CITY OF ALBUQUERQUE

**Re: Eagle Ranch NMDMV
9651 Eagle Ranch Rd NW
30-Day Temporary Certificate of Occupancy- Transportation Development
Transportation Development Final Inspection
Architect's Stamp dated 06-07-17 (B13-D002C)
Certification dated 12-13-17**

NMDMV 9651 EAGLE RANCH RD NW
EAGLE RANCH RETAIL 9641 EAGLE RANCH RD NW - TCL SITE PLAN
ALBUQUERQUE, NEW MEXICO
PROJECT # 1620

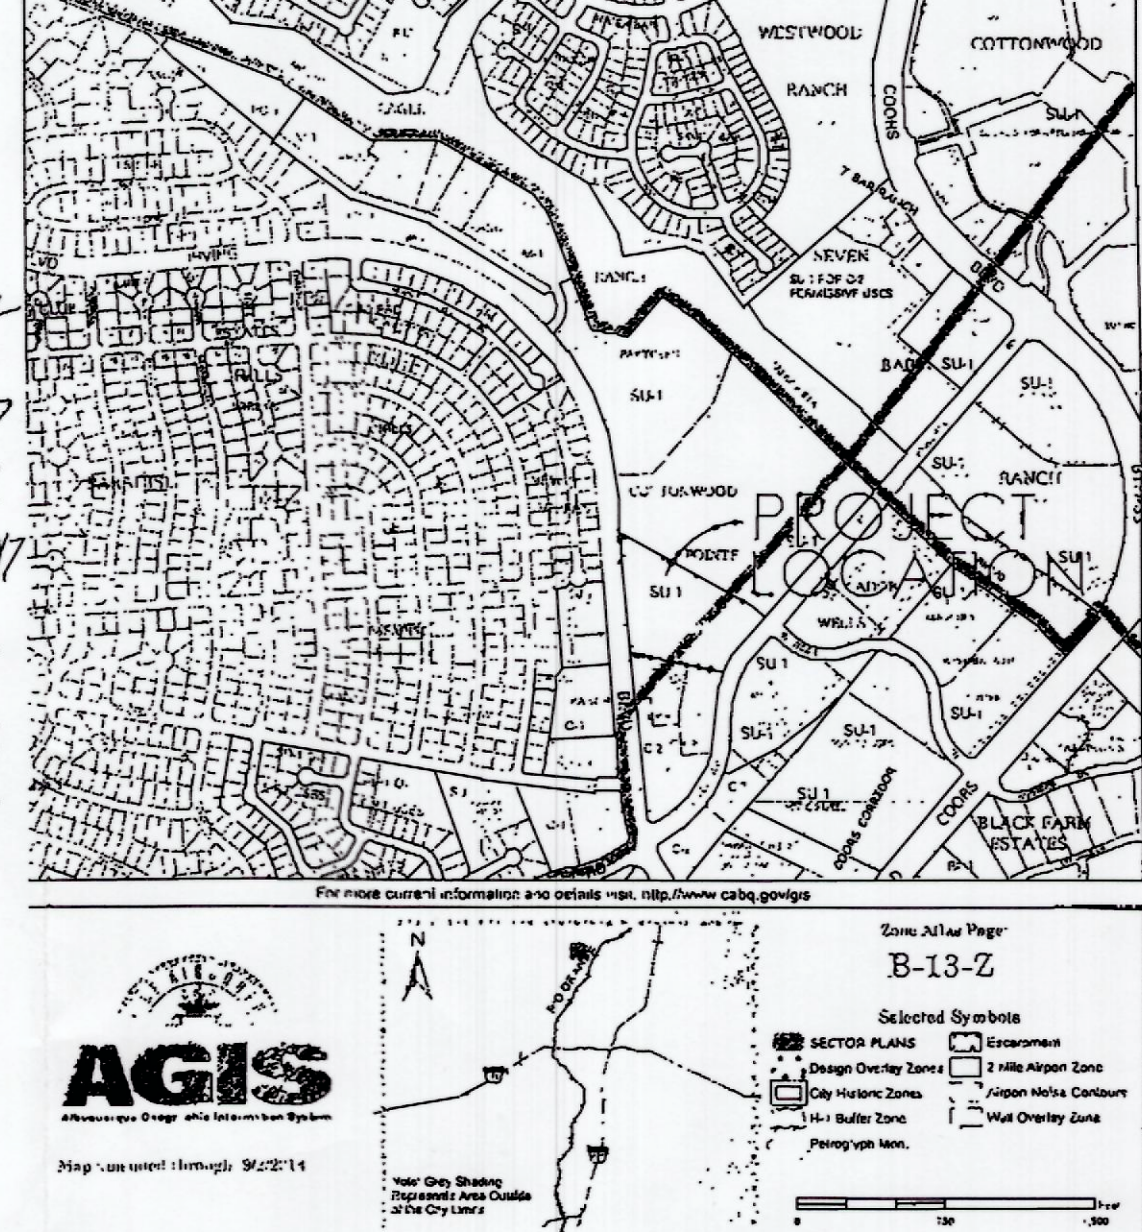
1. The ADA access aisles shall have the words **"NO PARKING"** in capital letters, each of which shall be at least one foot high and at least two inches wide, placed at the rear of the parking space so as to be close to where an adjacent vehicle's rear tire would be placed. (66-1-4.1.B NMSA 1978)
2. Motorcycle parking spaces must be designated by its own conspicuously posted upright sign, either free-standing or wall mounted per the zoning code.
3. One-way vehicular paths require pavement directional signage and a posted **"Do Not Enter"** sign at the point of egress.
4. ADA ramps cannot extend into the access aisles of the accessible parking spots.
5. The site plan should indicate that the road around the back of the site is base course and if it will be built in a later phase.
